West Keira, Wollongong – Stage 1

BCA Assessment Report

REPORT 2011/0432 R1.1

DETAIL 1: TUNNEL & BRIDGE ENLARGEMENT
SCALE 1:100

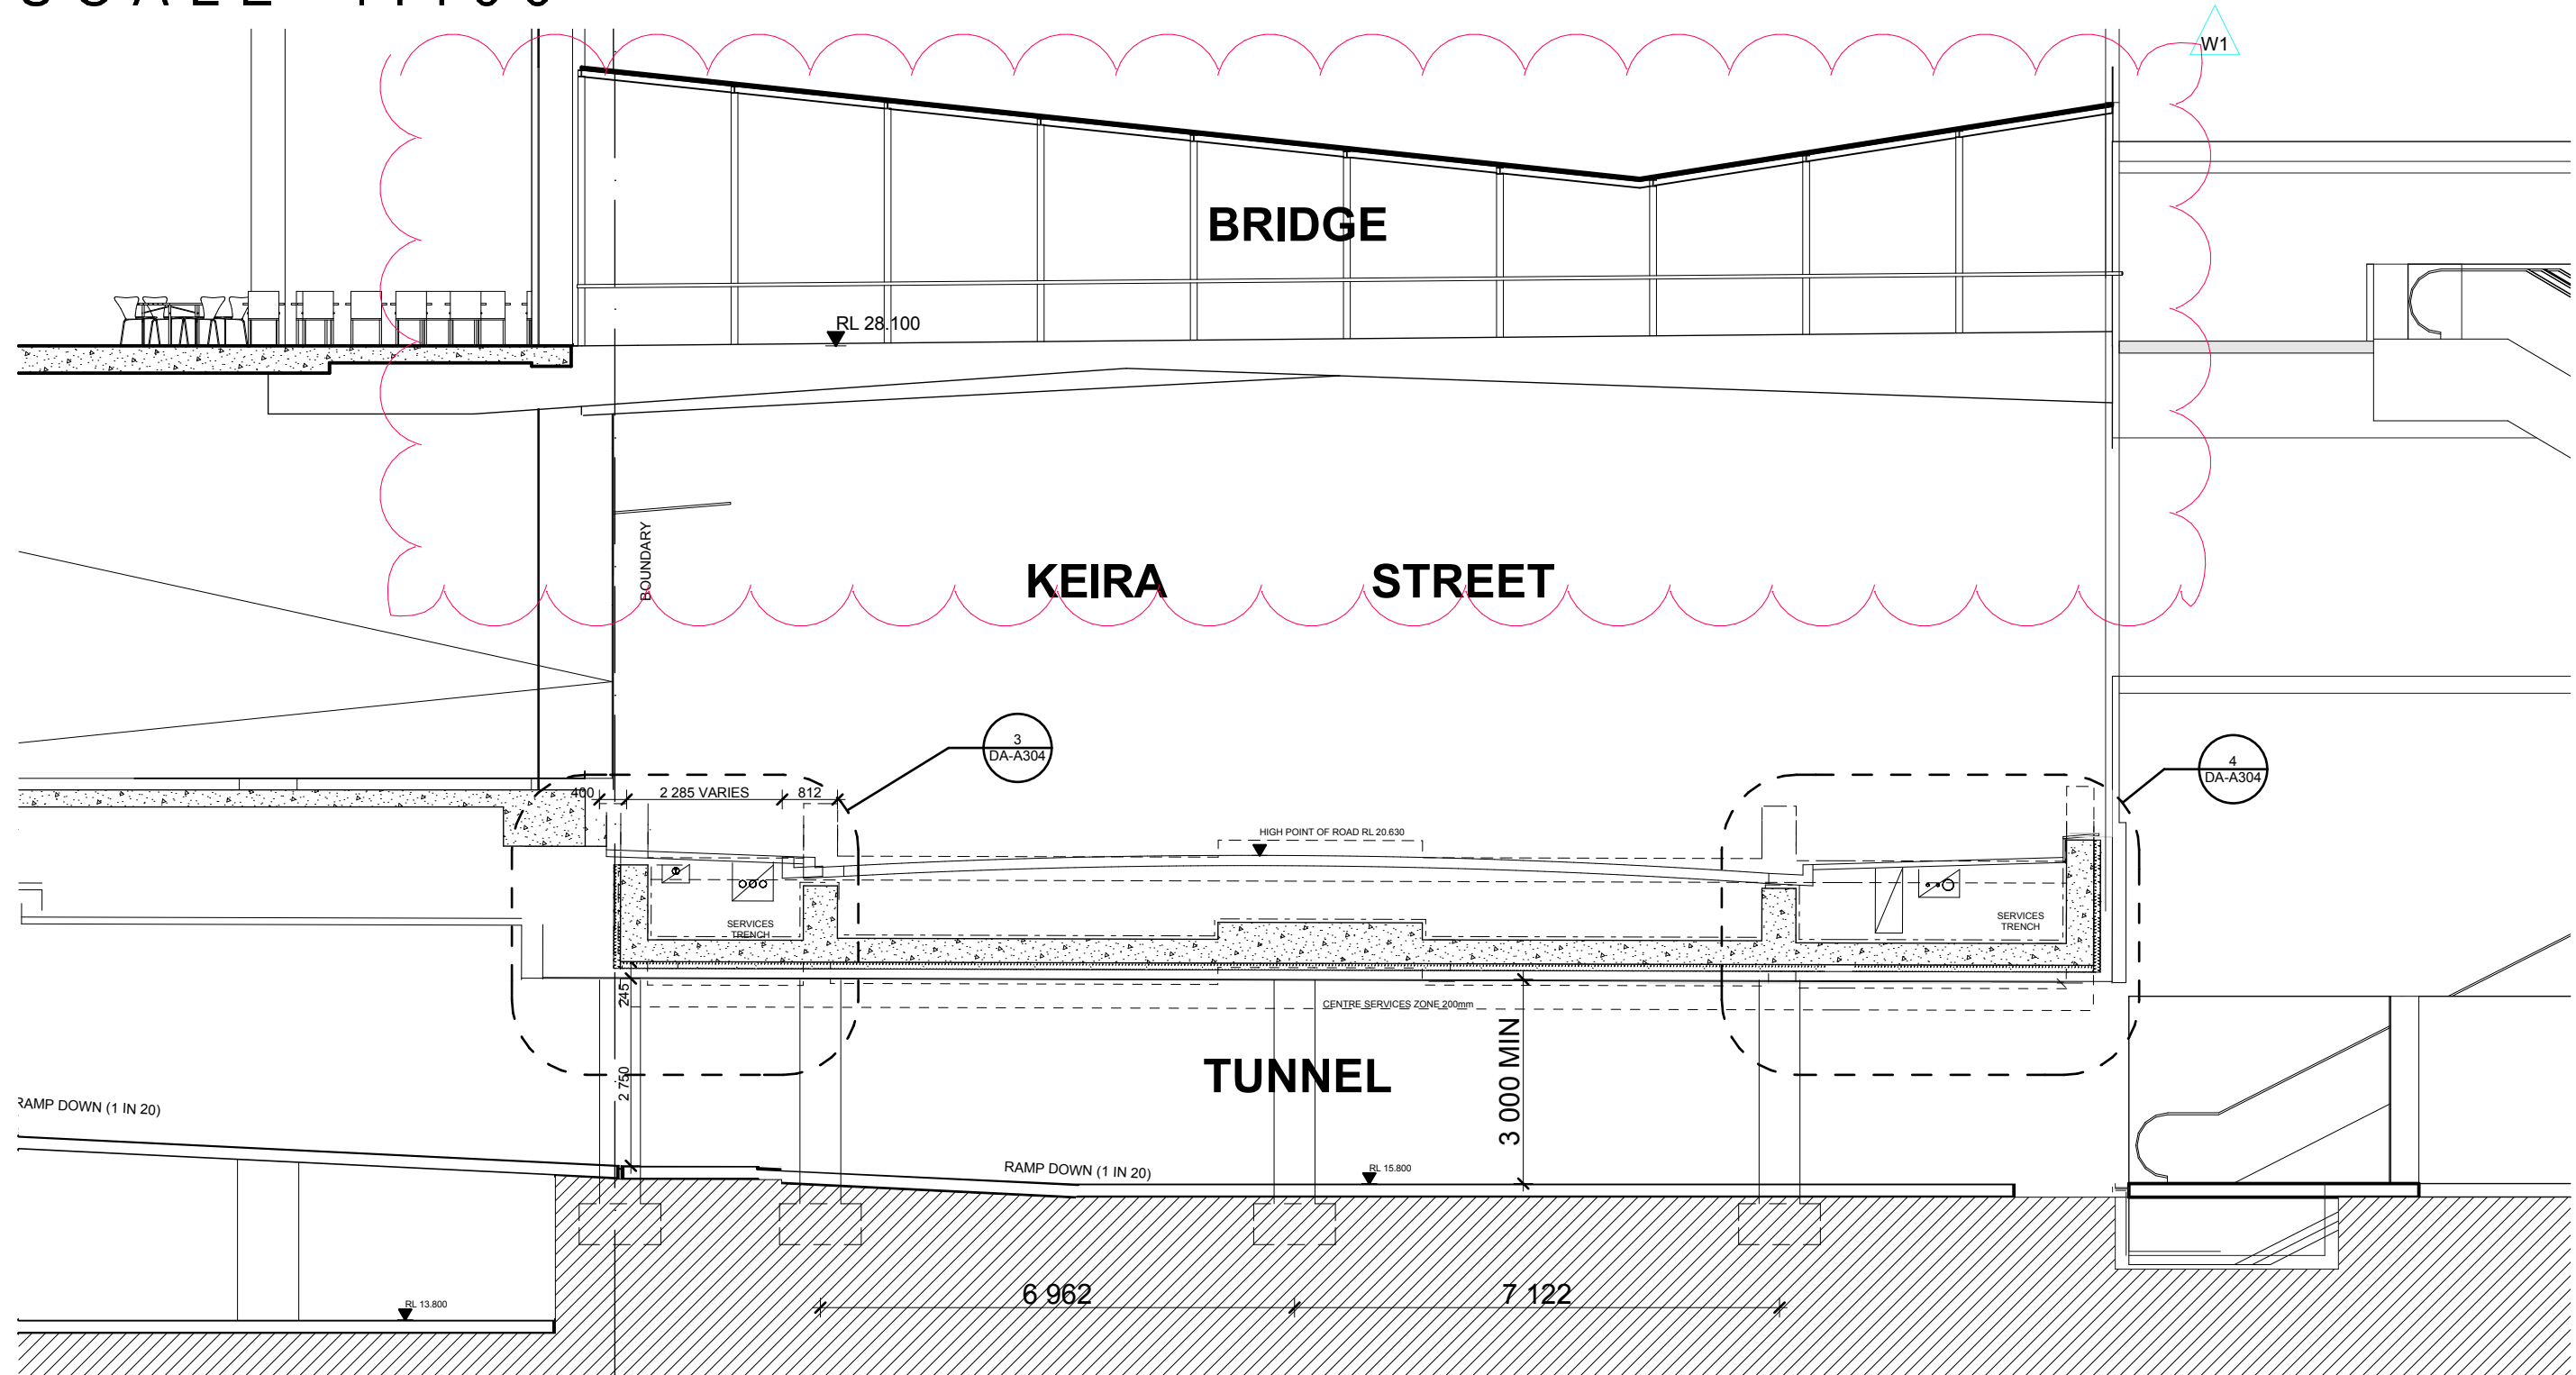
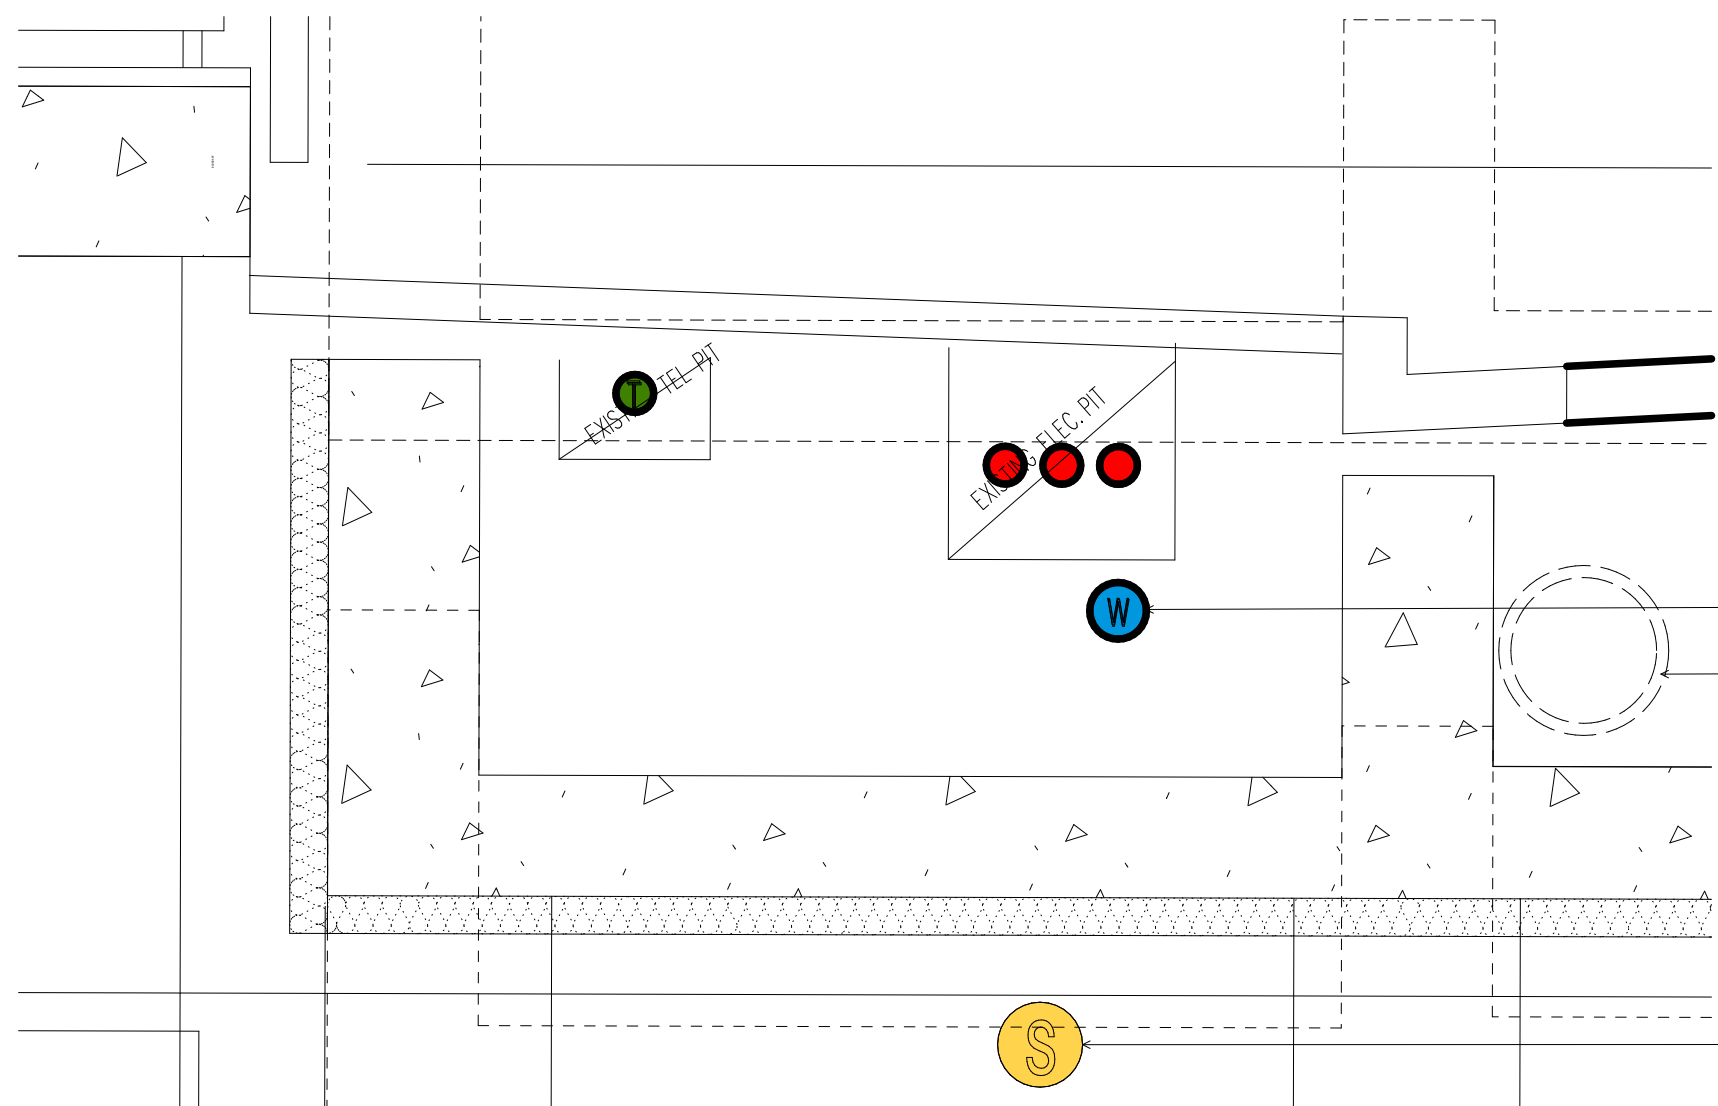
Item	DTS Clause	Description of Non-compliance	Requirement to Satisfy BCA
1.	C2.7	The new pedestrian bridge and underground tunnel new West Keira site is required to be fire separated from the existing Wollongong Central Shopping Centre by 3 hour construction. A fire wall must extend through the connection point of the two centres.	<p>It is proposed to have a "non physical" method of fire separation. The following options are available:</p> <ul style="list-style-type: none"> i. A sliding fire door in accordance clause C3.6 of the BCA. Note the door can be concealed within a side wall cavity; or ii. A fire curtain concealed within the ceiling space. <p>Note the curtain is a performance based measure and will need to be assessed by the Fire Engineer.</p> <p>Details are to be provided on the CC plans.</p>

2.			The external walls of the pedestrian bridge enclosure are within 1.5m of the Wollongong Central building and the boundary. The enclosure is required to have a FRL of 180/180/180 and any associated openings protected in accordance with Clause C3.4 of the BCA.	CP1 & CP2	The bridge structure and fire separation is to be reviewed by the fire engineer and justified in the fire engineering solution.
